DOC19/852116-3

Development Application – Proposed Snowy 2.0 Main Works (SSI 9687)

The EPA has reviewed the publicly exhibited Environmental Impact Statement (EIS) for the proposal "*Snowy 2.0 Main Works – Environmental Impact Statement*", prepared by EMM Consulting dated 13 September 2019 and provides the following comments for DPIE's consideration. Attachment 1 to this letter outlines the specific details, with the EPA's recommendations highlighted in *italics*.

Figure 6.4 Ravine Bay placement footprint and section

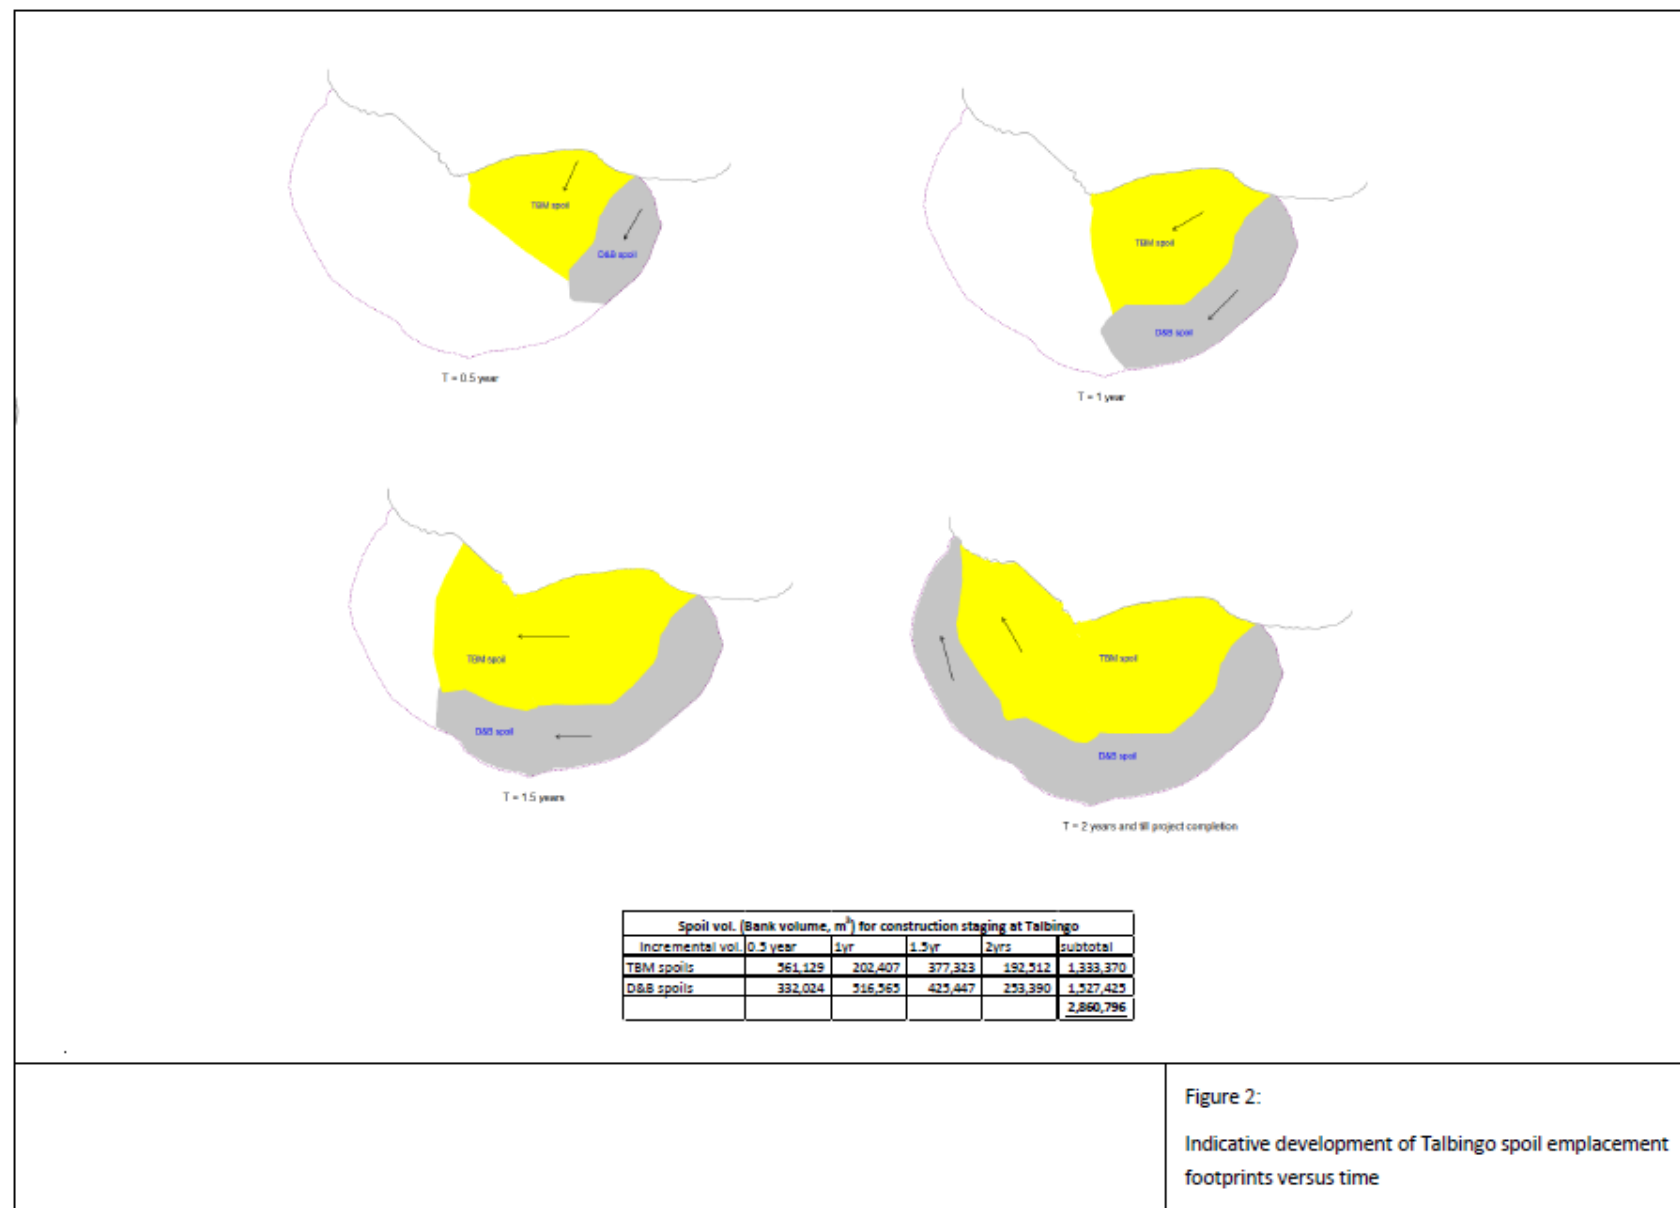
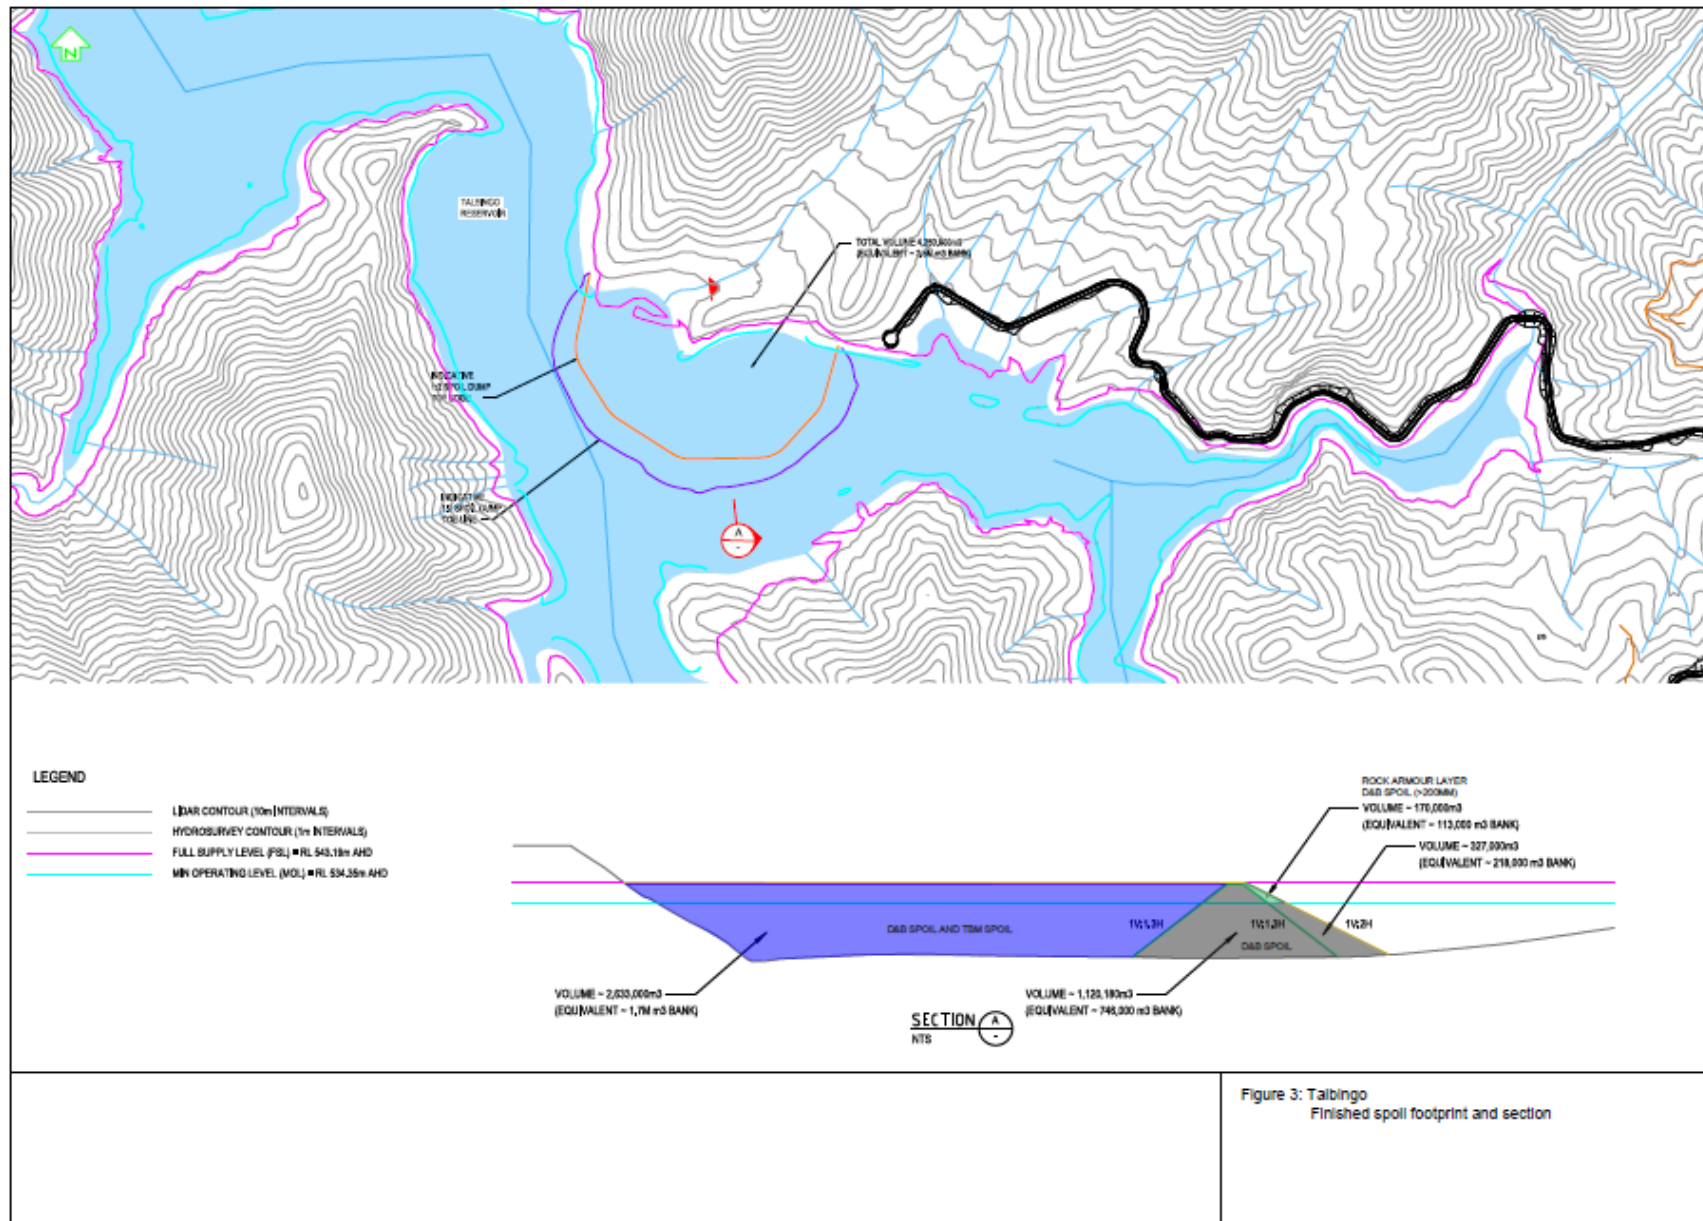
Placement of material will smother benthic animals, plants and habitats. The EIS does not specify the area of the placement footprint under the proposed or 'hybrid' excavated rock placement methods. However, the 'hybrid' method is expected to require a much smaller footprint and is therefore likely to have a reduced impact on the receiving environment.

- i. ***Specify the area of the proposed excavated rock placement footprint, detailing how this was determined with reference to the bulked volume of excavated material proposed to be placed.***

Figure 6.11 Tantangara Reservoir emplacement area footprint

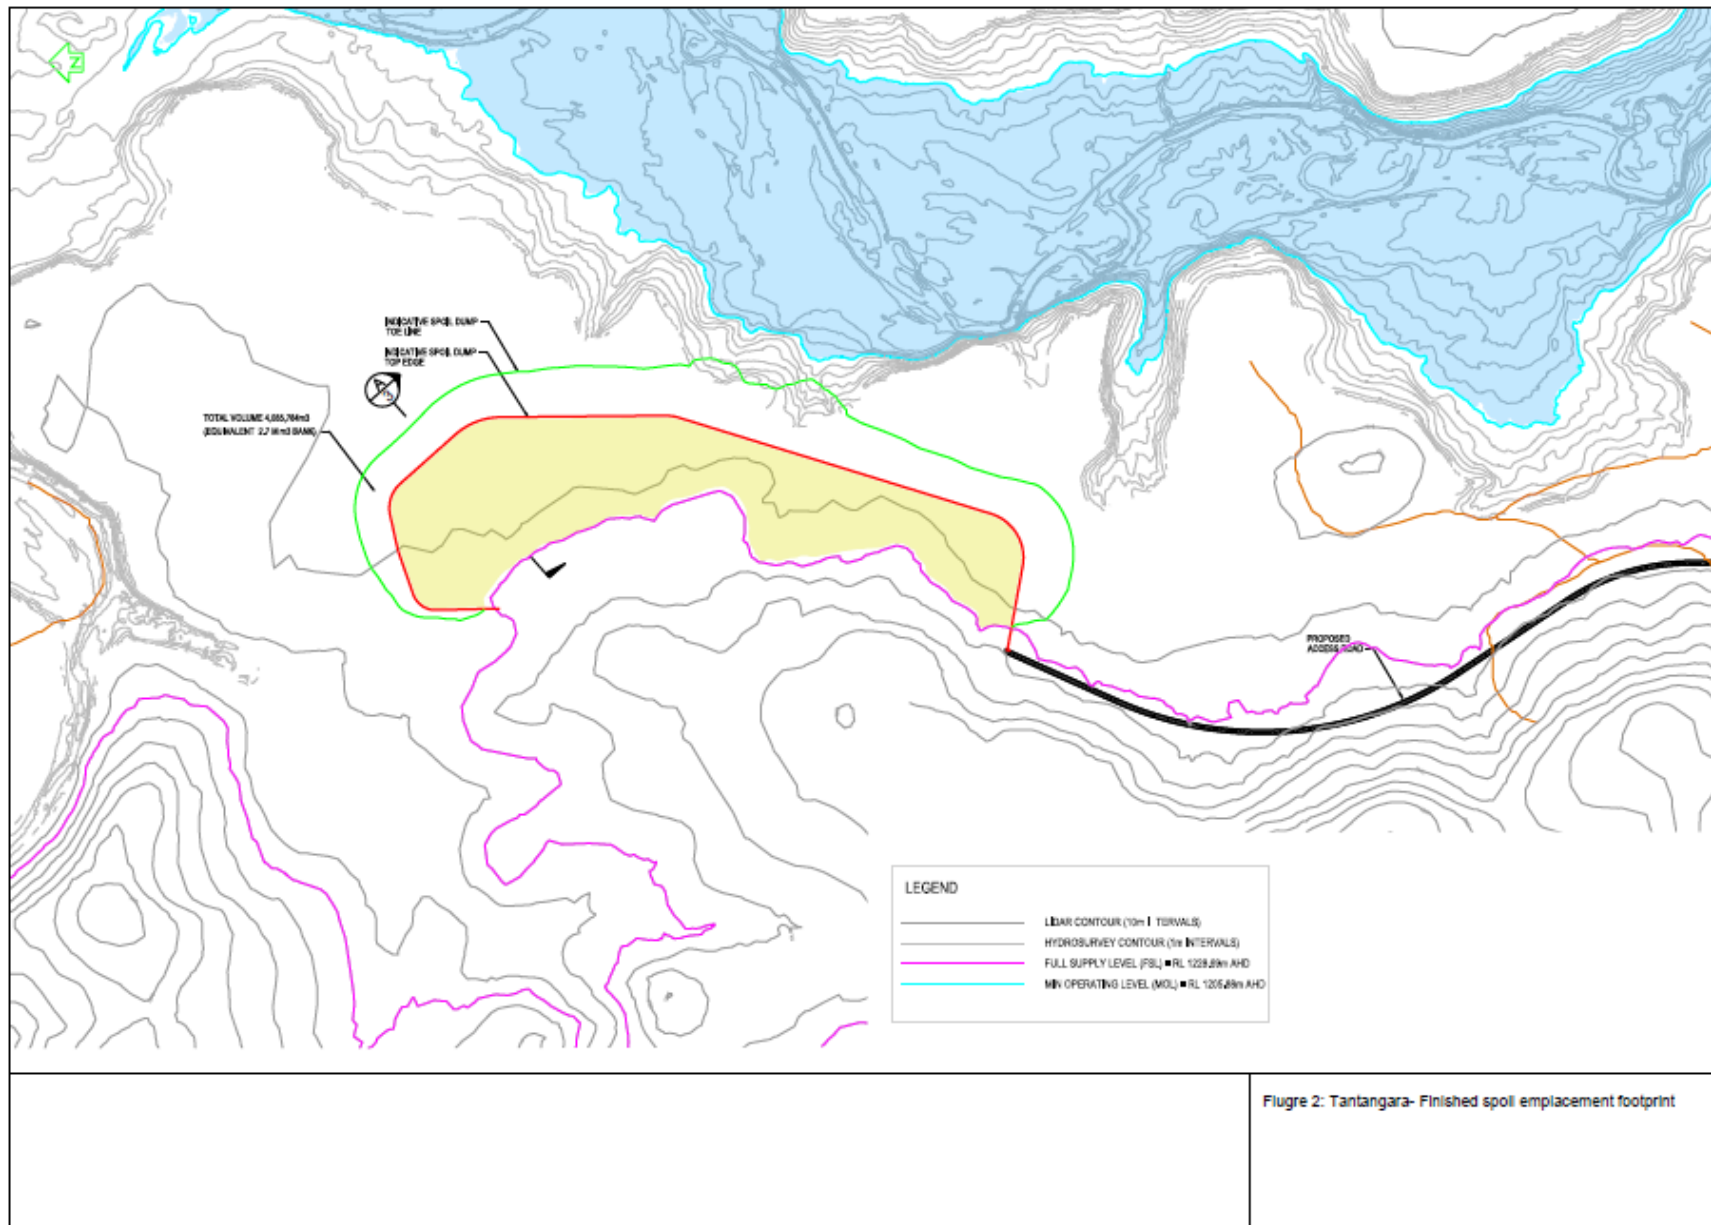
There is a risk that as water levels rise and fall in Tantangara Reservoir that fine sediment and other pollutants are released from the excavated rock placement. However, the EIS:

- provides limited information about the placement methods
- does not include an assessment of the potential impact of release of fine sediment and associated pollutants during wetting and drying cycles
- does not provide details of the measures that will be implemented to mitigate potential water pollution risks.

- **provides details of the proposed excavated rock placement methods and mitigation measures for Tantangara Reservoir**
- **assesses the potential for release of sediment and other pollutants (e.g. aluminium) associated with wetting and drying of the Tantangara Reservoir rock emplacement as the level of the reservoir rises and falls. If a risk is identified, the potential impact on water quality should be assessed and any appropriate mitigation measures identified. This assessment should be supported by appropriate hydrodynamic modelling of plume behaviour under a range of scenarios**
